Addendum No. 1

RE: Contract # C204150

Guilford County (U-5896, B-5353)

US-29/US-70/I-85 BUSINESS, SR-1009 (S MAIN ST) IN HIGH POINT
AND BRIDGE #147 OVER US-311 ON US-29/US-70/I-85 BUSINESS

PROJECT REFERENCE NO.	SHEET NO.
U-5896	UC-5C
DESIGNED BY: DMP	
DRAWN BY: DMP	
CHECKED BY: DMP	
APPROVED BY:	
REVISED:	
NORTH CAROLINA DEPARTMENT OF TRANSPORTATION	1/31/2022
UTILITIES ENGINEERING SEC. PHONE: (919) 707-6690 FAX: (919) 250-4151	UTILITY CONSTRUCTION PLANS ONLY

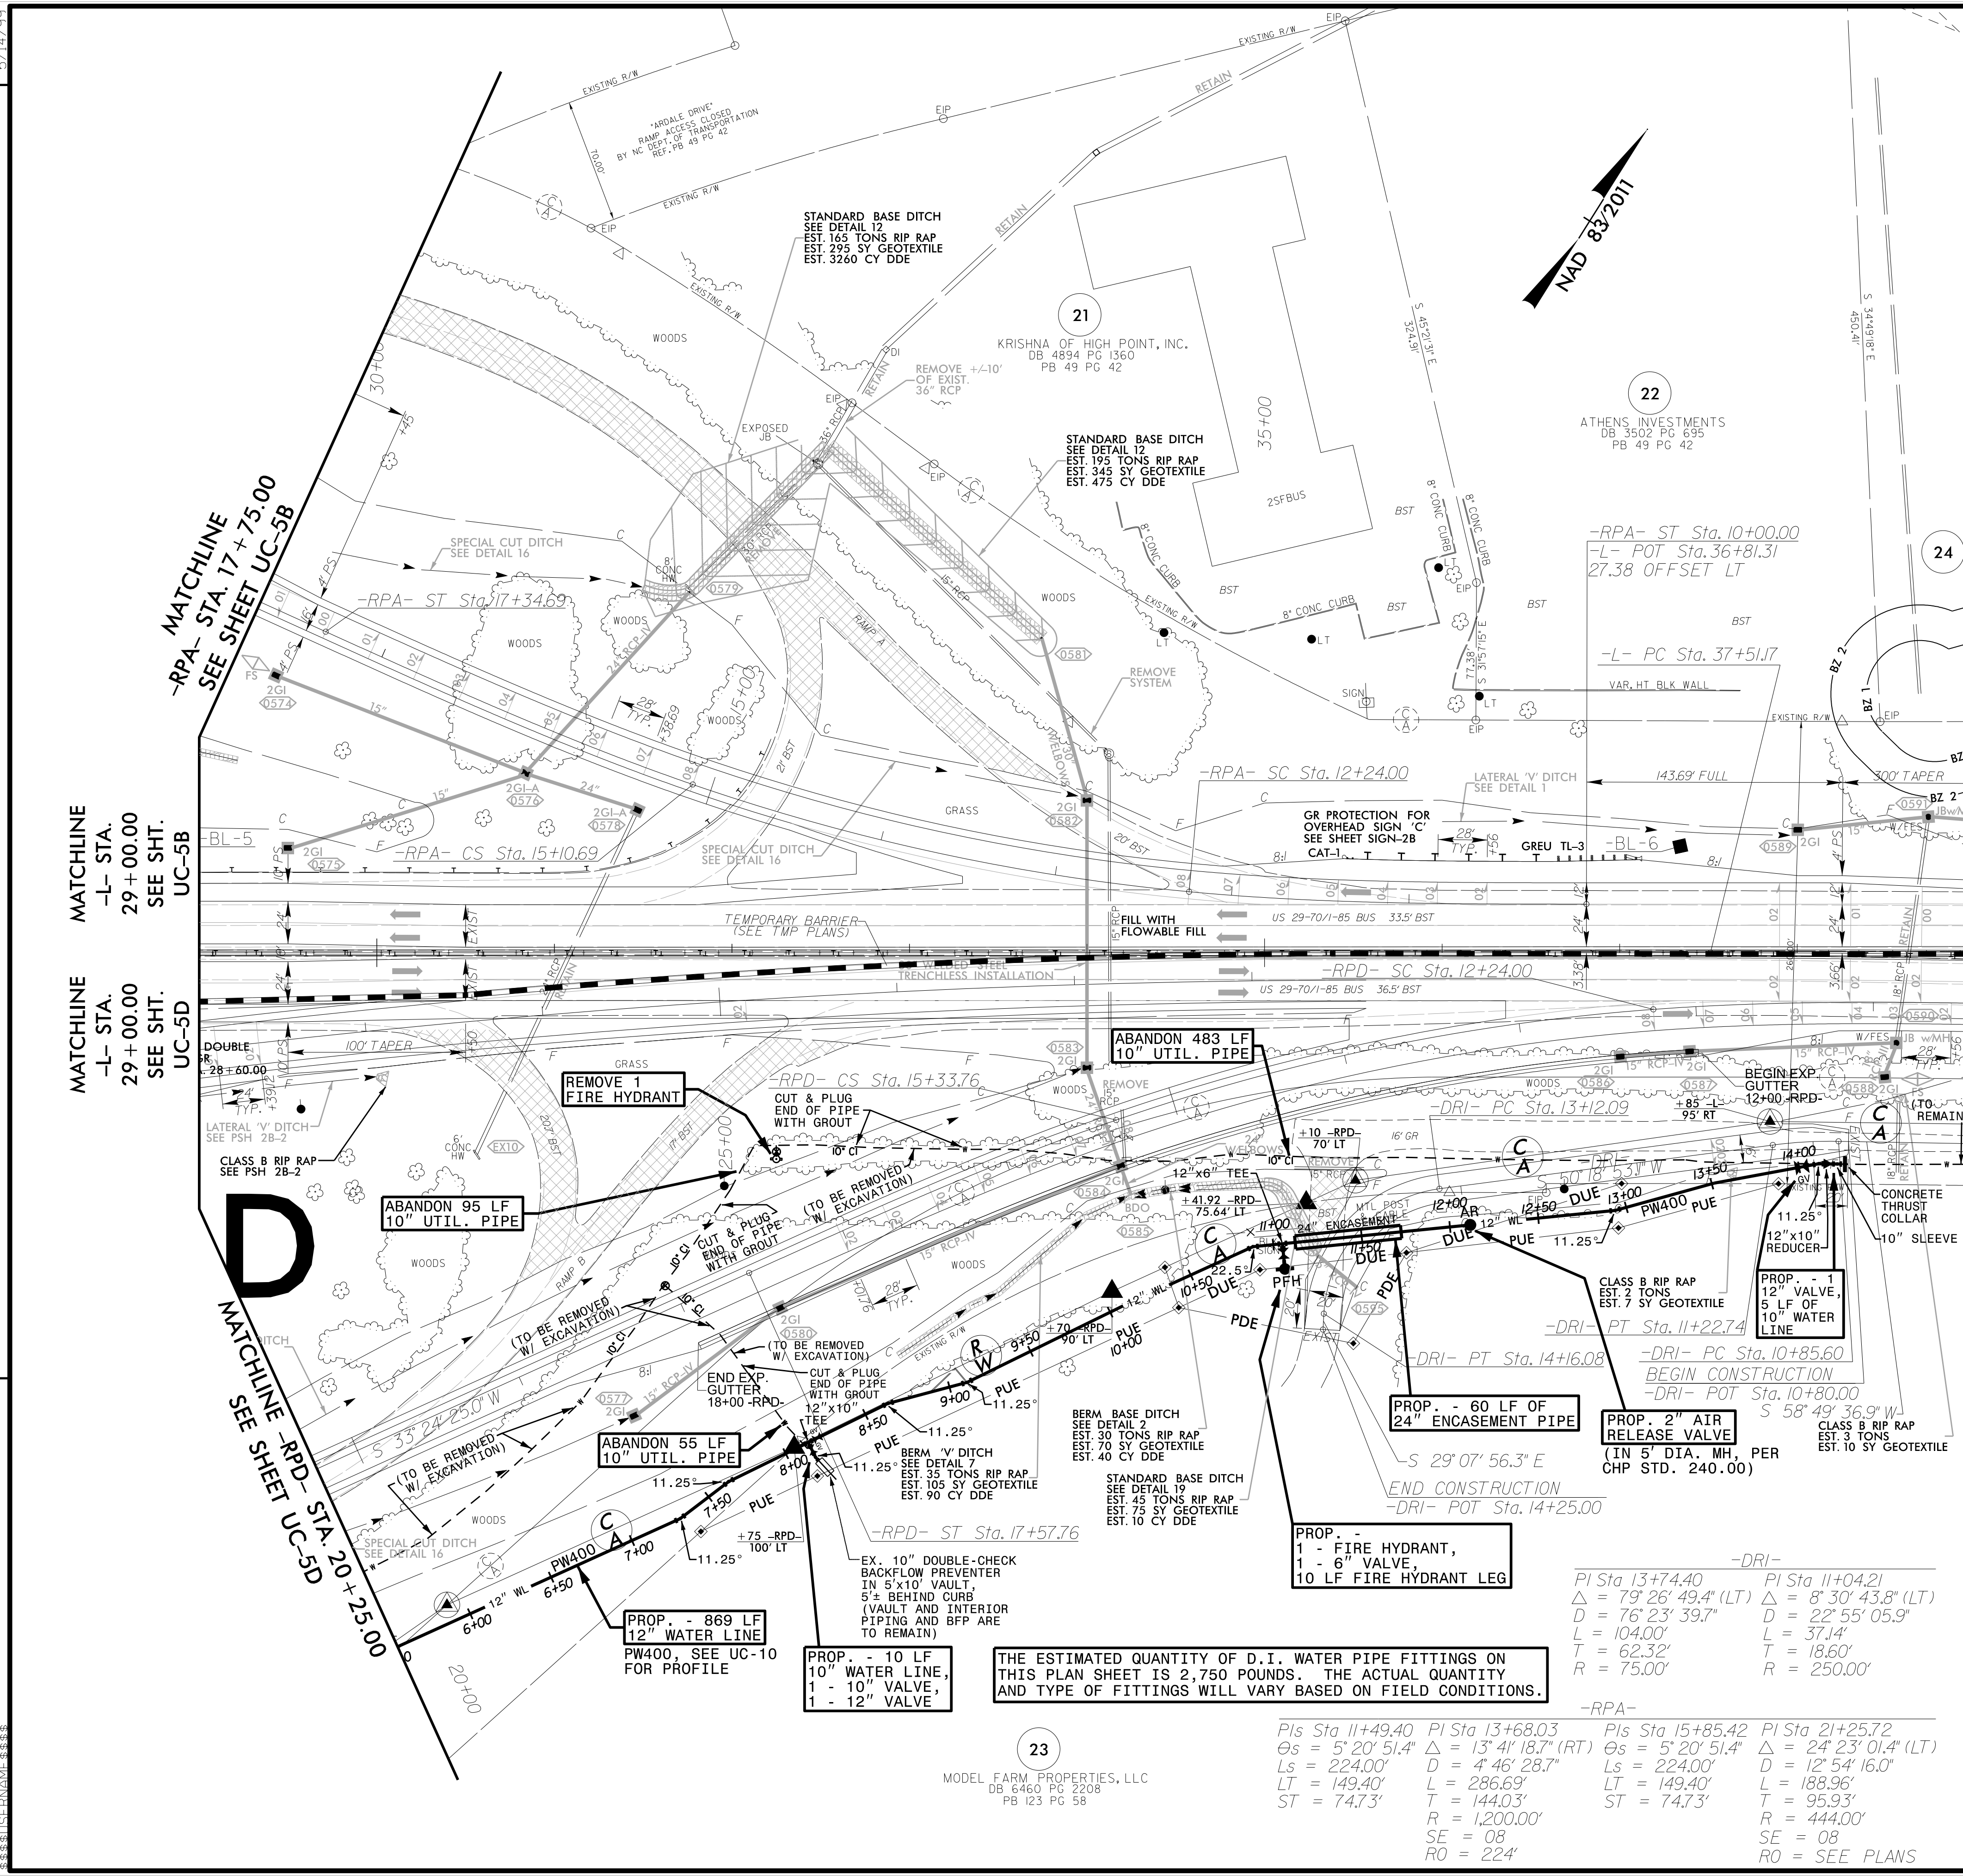
Sheet No.	Revision
UC-5C	Added 12" Valve at STA. 8+20 on PW400. Revised quantity of 10" Water Line from 12 LF to 10 LF for 10" branch water line at STA. 8+14 on PW400. Added 5 LF of 10" Water Line at end of PW400
UC-7	Added 12" Valve at STA. 14+36 on PW200. Added note for 12" DI Plug with 2" Tap at end of PW200. Added notes about ex. 8" water line to remain next to -Y1-, and ex. 6" water line to be abandoned at -Y1-
UC-8	Added 12" Valve at STA. 14+36 on PW200. Showed 2" Valve at STA. 0+62 on PW300 (this 2" Valve was already shown in plan view on Sheet UC-7)
UC-10	Added 12" Valve at STA. 8+20 on PW400
